Our Ref: FG/181/18/PL
Your Ref:

Town & Country Planning Act 1990 (as amended)
Town and Country Planning (Development Management Procedure) (England) Order 2015
Application for Planning Permission

Development Erection of a single storey, timber structure woodworking shop
Location Ferring Country Centre And Riding Stables Rife Way Ferring

Block Plan shows area bounded by: 506842 42, 102940 84 538632 42, 103030 84 (at a scale of 1:500), OSGridRef: TQ 888 298. The representation of a road, track or path is no evidence of a right of way. The representation of features as lines is no evidence of a property boundary.

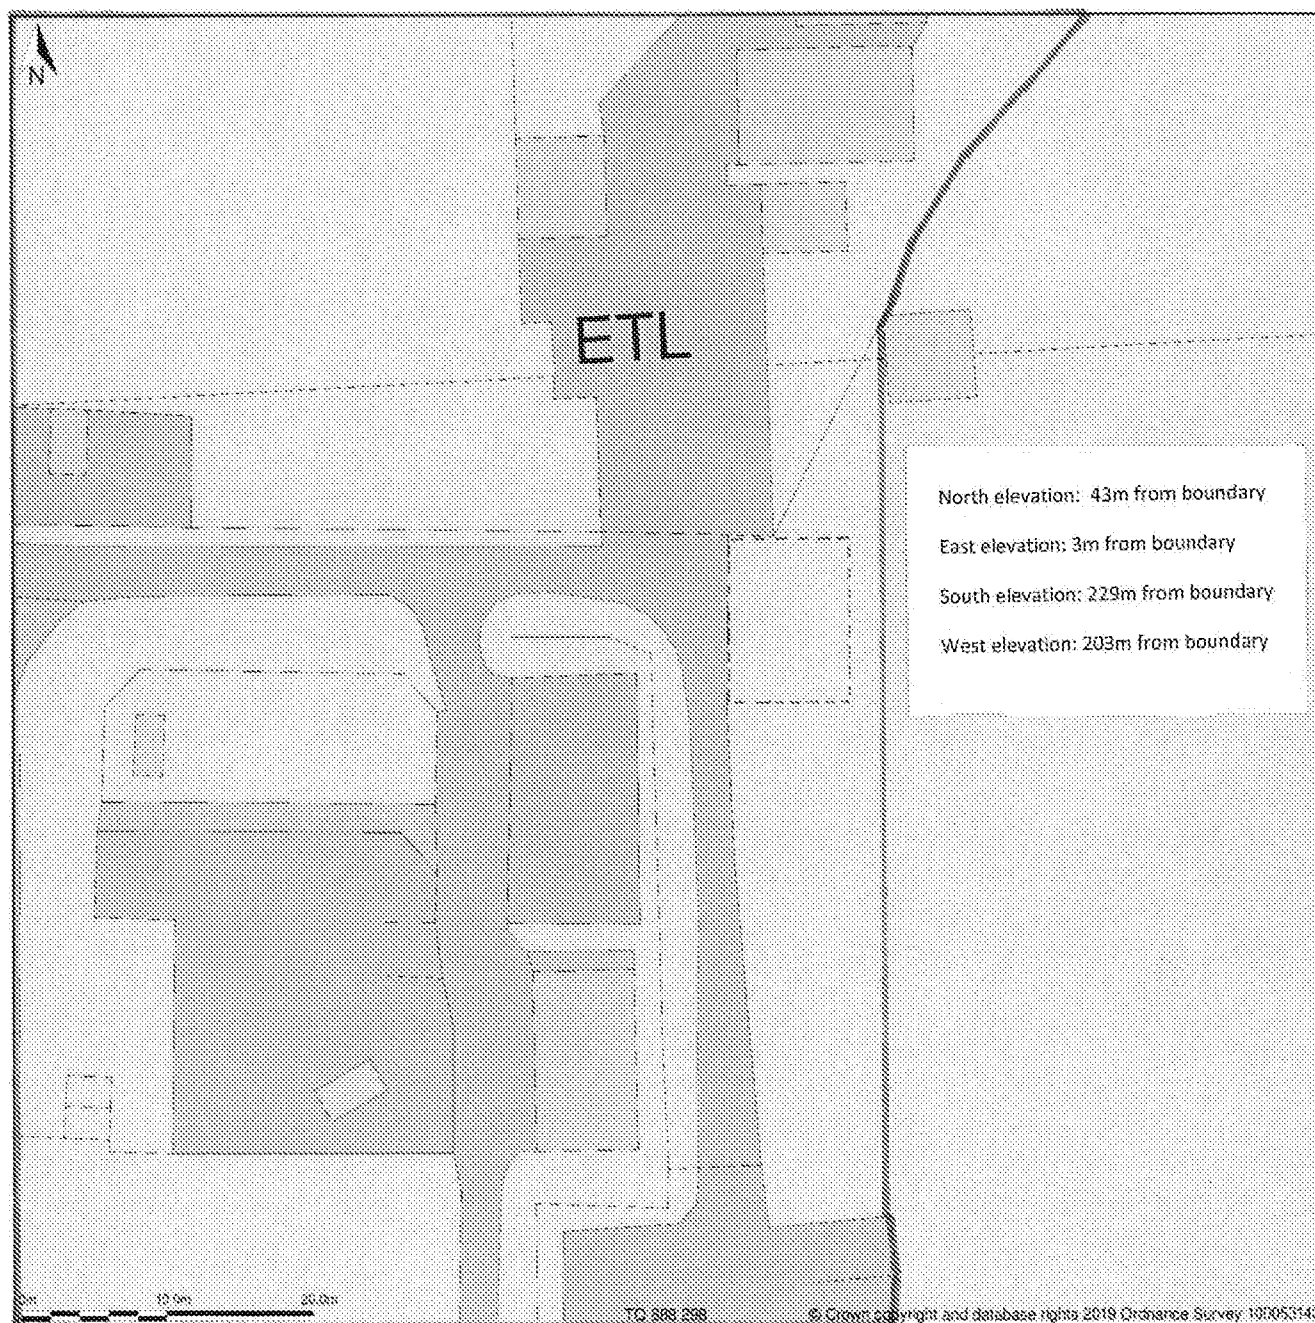
Please confirm that the red site outline is correct. If so, please complete the gaps where the access meets the public highway.

Front Elevation

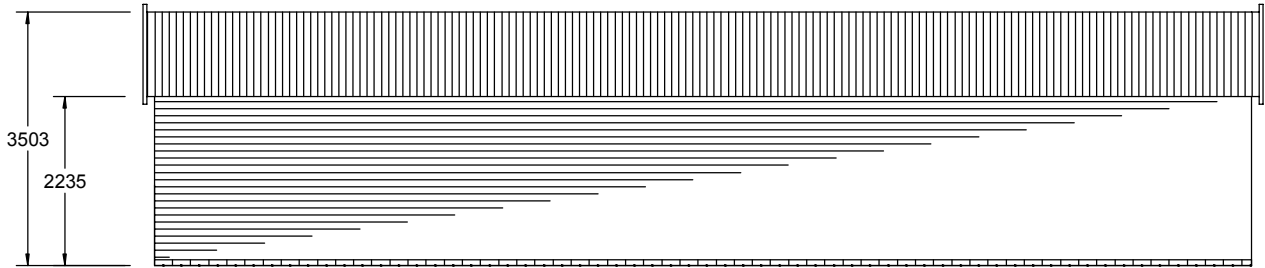
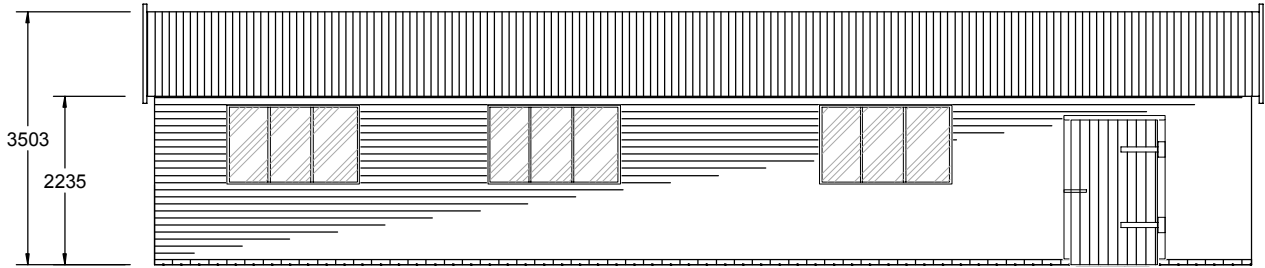
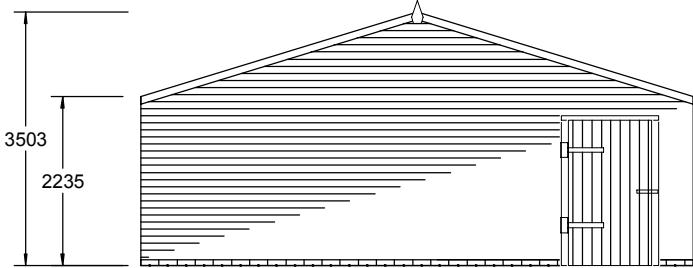
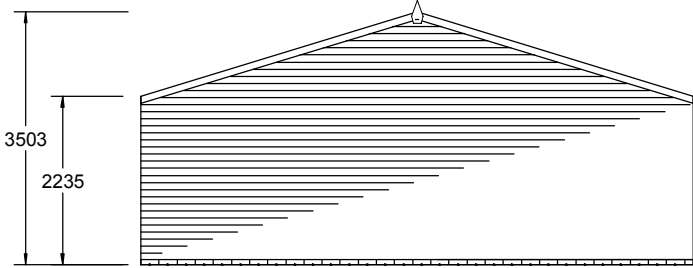
Please submit all proposed elevations at a scale of 1:50 or 1:100. Further details can be found in the National Validation Requirements.

Base Plan

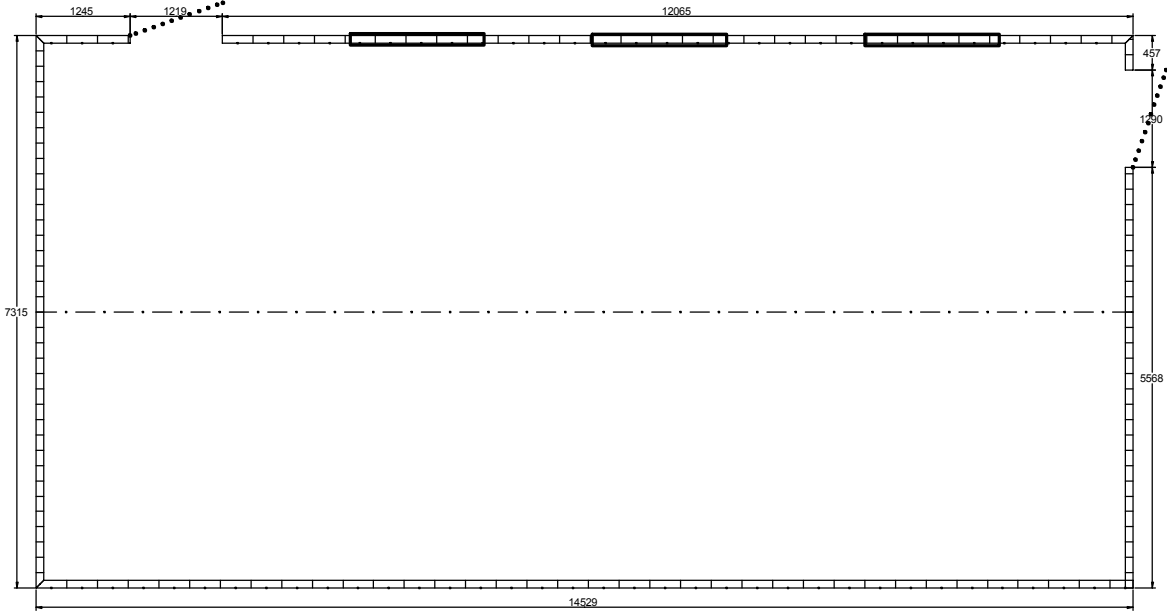
The floor plans need to be drawn to a stated standard scale such as 1:50 or 1:100. Further details can be found in the National Validation Requirements.
